Subject: 23.05.19 ESC Plan comments for Galles Chevrolet Parking Lot at 2001 Candelaria Rd. NE & Motel 1 Demo - H15E007 - NMR1005MK

Subject: 23.04.17 ESC Plan comments for Galles Chevrolet Parking Lot at 2001 Candelaria Rd. NE & Motel 1 Demo - H15E007 - NMR

INTERIM GRADING & DRAINAGE PLAN

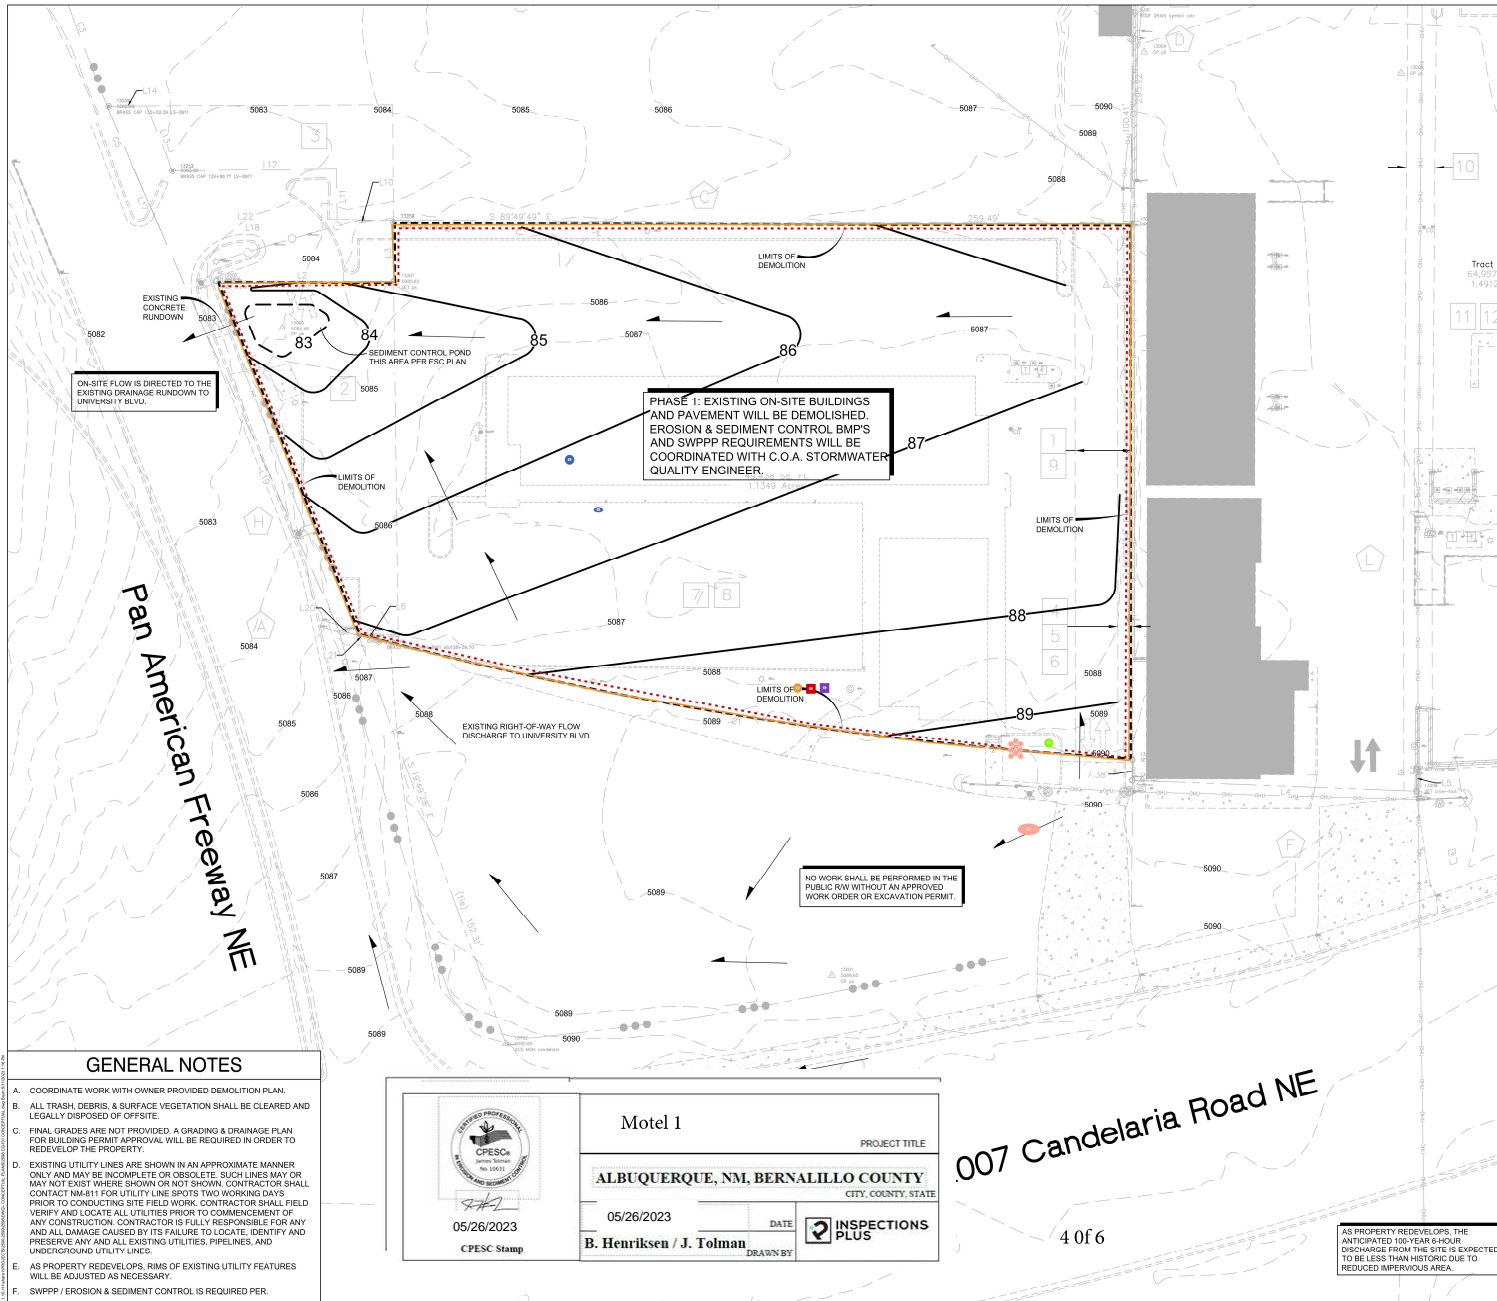
It seems like the plan is to get rid of the building and parking lot and to leave bare dirt until sometime in the future. There isn't any acknowledgement of the permit requirements that will apply to the dirt lot. If the lot is to remain inactive for 14 days or more, you must begin applying seed and hydromulch within 14 days, and you must complete the seed and mulch within in 14 days from the day you start per CGP 2.2.14. Then you must continue permit coverage, self-inspections, SWPPP and BMP maintenance until the City determines that the Final Stabilization Criteria CGP2.2.14.c has been satisfied.

Untitled Map

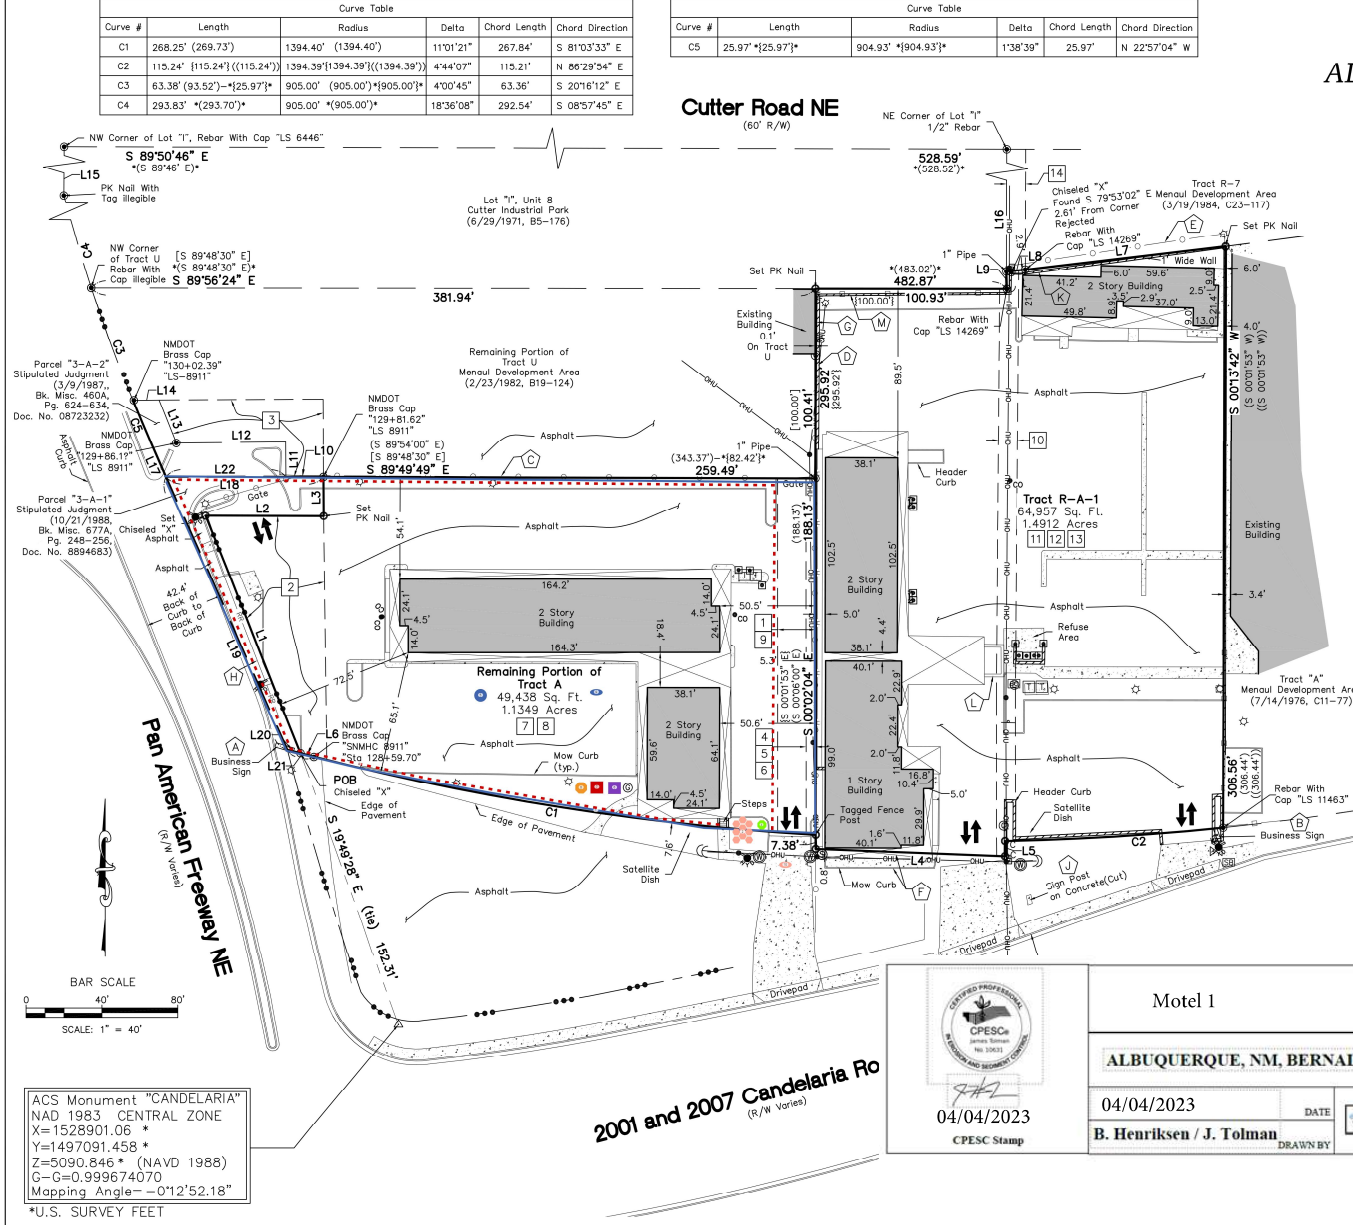
The demolition of the Motel 1 building and parking lot requires an NOI and SWPPP. See attached DEMO exhibit. The paved area south of Motel 1 is in the public ROW and is labeled "fenced but will not be disturbed". Apparently Galles Chevrolet is leasing the Motel 1 property, but the plans for this site are vague and nearly nonexistent. If so, Galles will need an NOI and I will need to verify the lease.
